Ribble Valley Borough Council
Council Offices
Church Walk,
Clitheroe
Lancashire
BB7 2RA

Your ref: 3/2025/0155

Date: 07 April 2025

Location: Healings Farm West Bradford Road Waddington BB7 3JE
Proposal: Proposed demolition of existing building and erection of a new dwelling with associated annexe.
Grid Ref: 373537 444037

Drawing No. GA_07

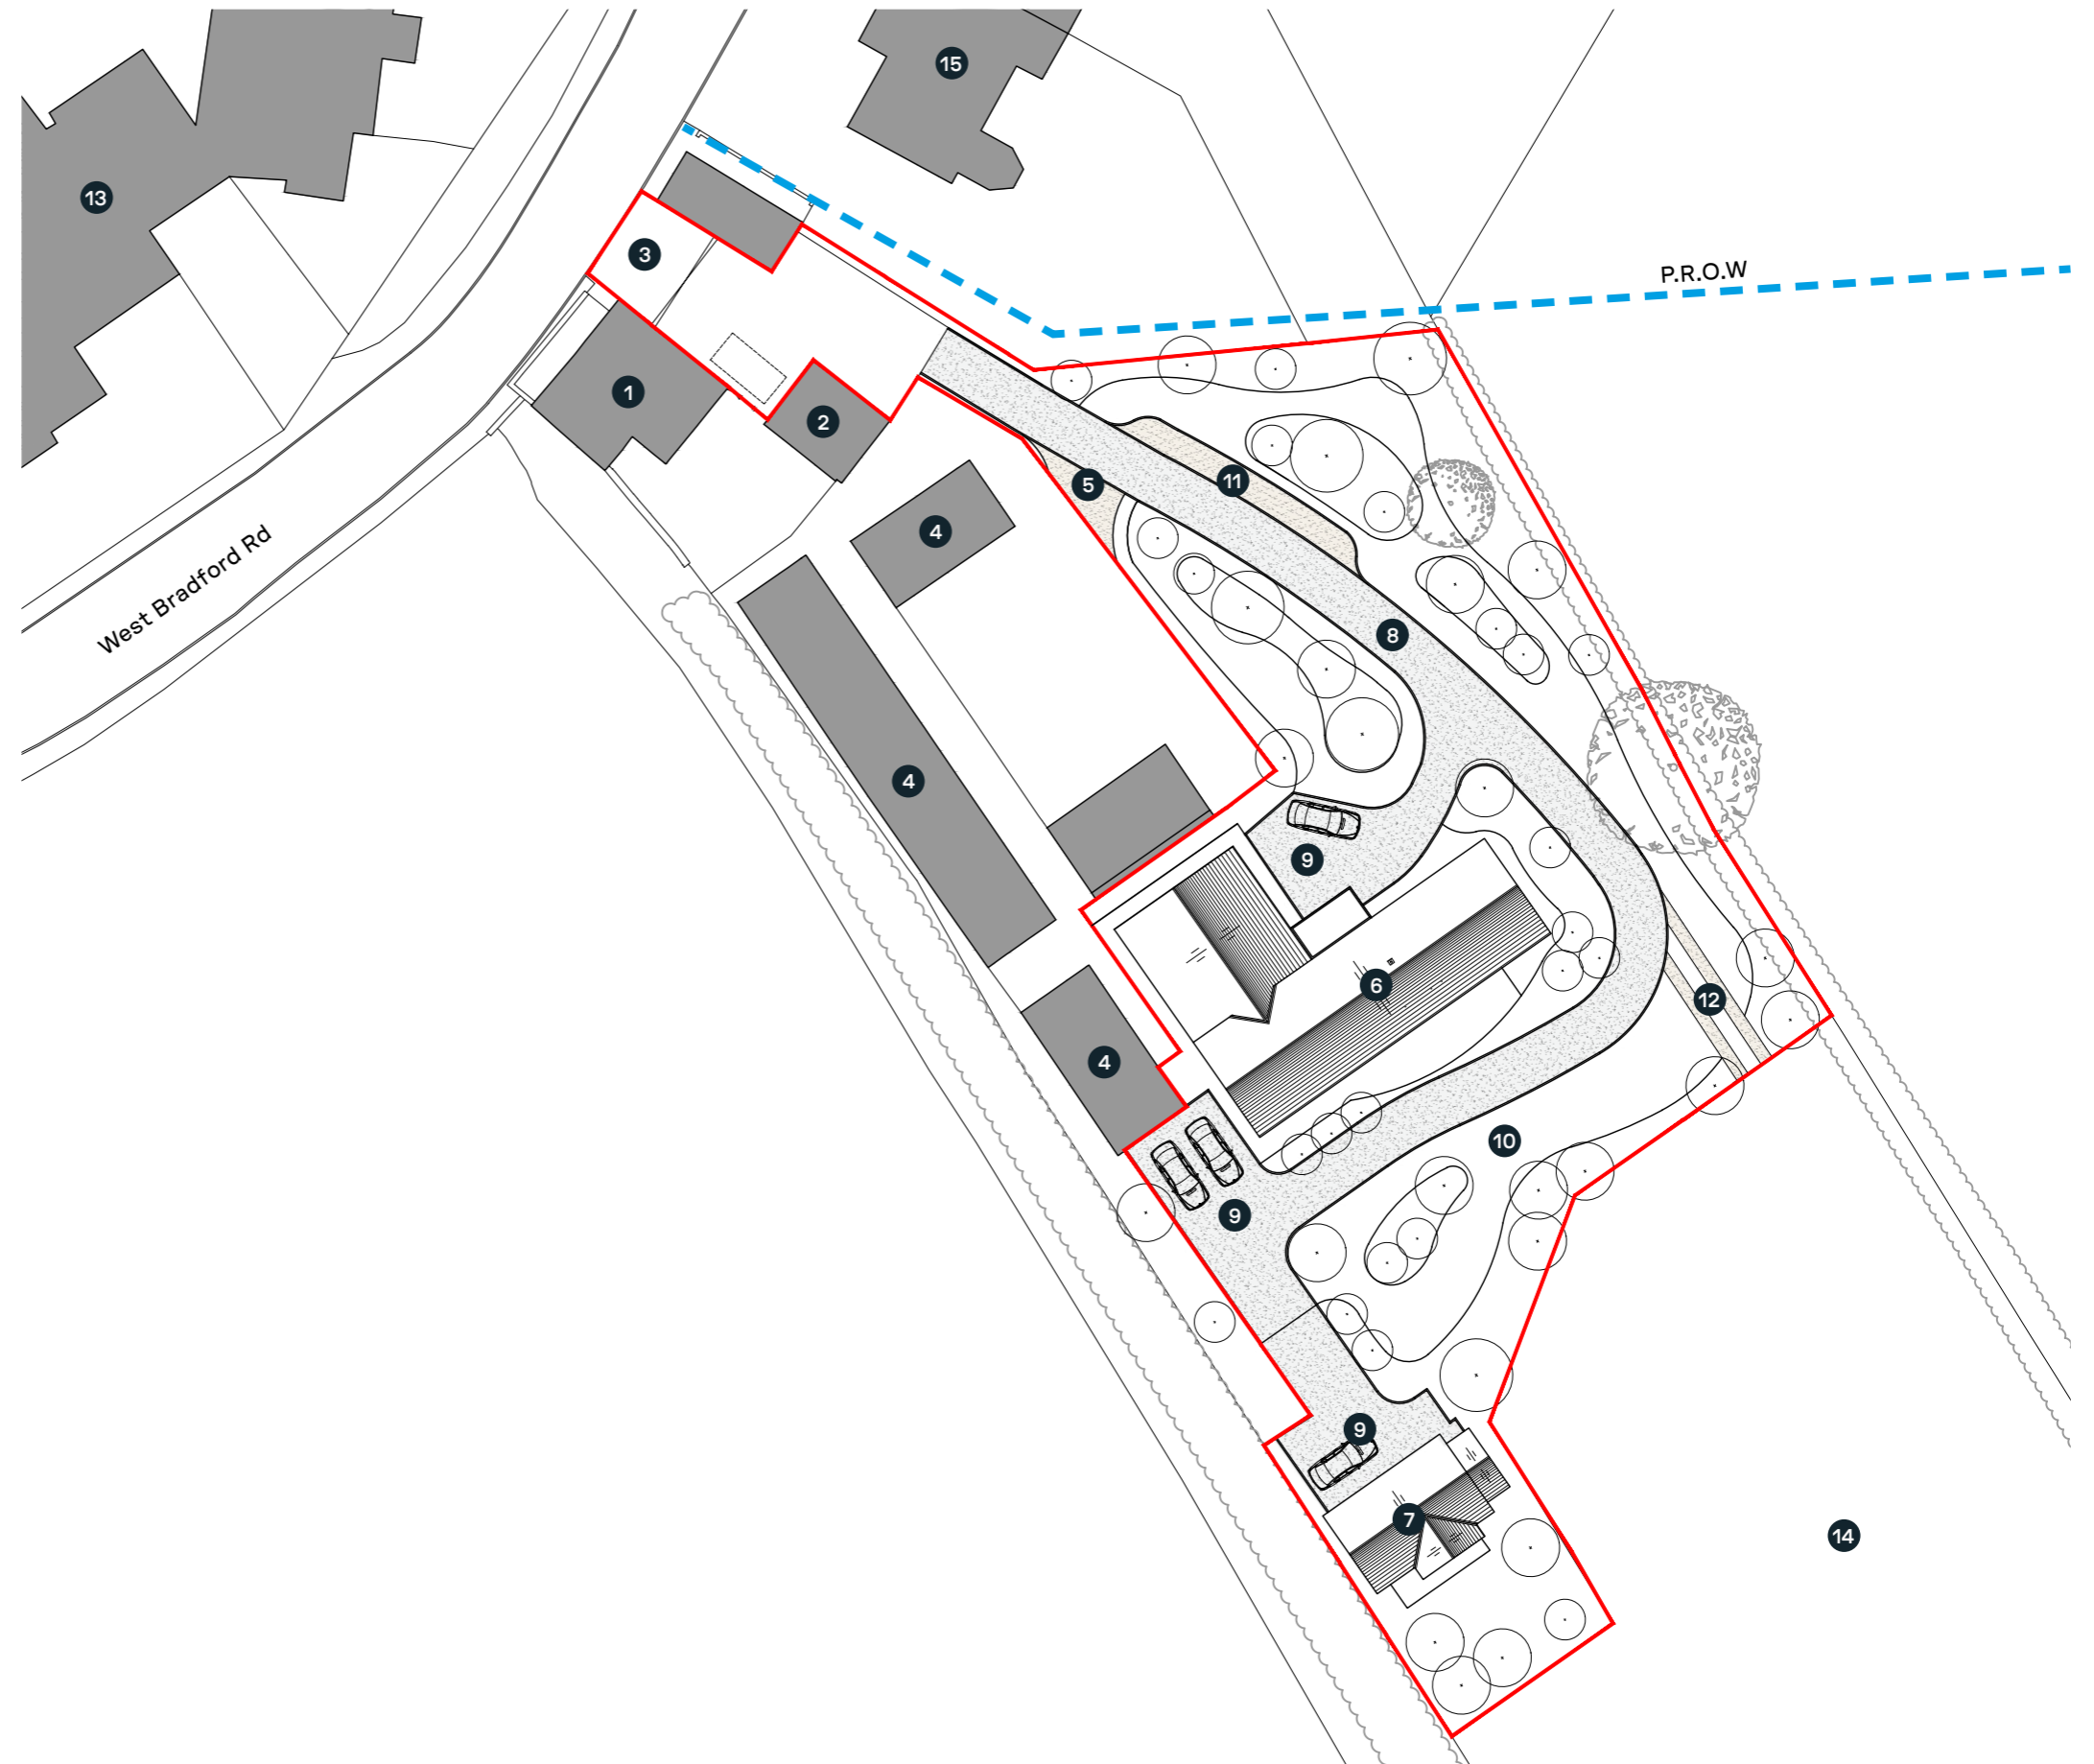
The LHA have reviewed drawing number GA_07 titled "Site Plan As Proposed" and are aware that 3 car parking spaces will be provided for the 4 bed dwelling which complies with the parking guidance as defined within the Joint Lancashire Structure Plan.

Furthermore, drawing number GA_07 shows a proposed formalised internal access track which will serve the site. The proposed access track connects the access to an agricultural field, two dwellings (including the one proposed) and a number of buildings which are used for light industrial purposes. The internal track will be approximately 3.5m wide which complies with the LHAs guidance. The LHA also welcome the introduction of a passing place along the track.

3. No part of the development hereby permitted shall be occupied until such time as the access and access track arrangements shown on Rural Solutions drawing number GA_07 have been implemented in full.
Reason: To ensure that vehicles entering and leaving the site may pass each other clear of the highway, in a slow and controlled manner, in the interests of general highway safety and in accordance with the National Planning Policy Framework.
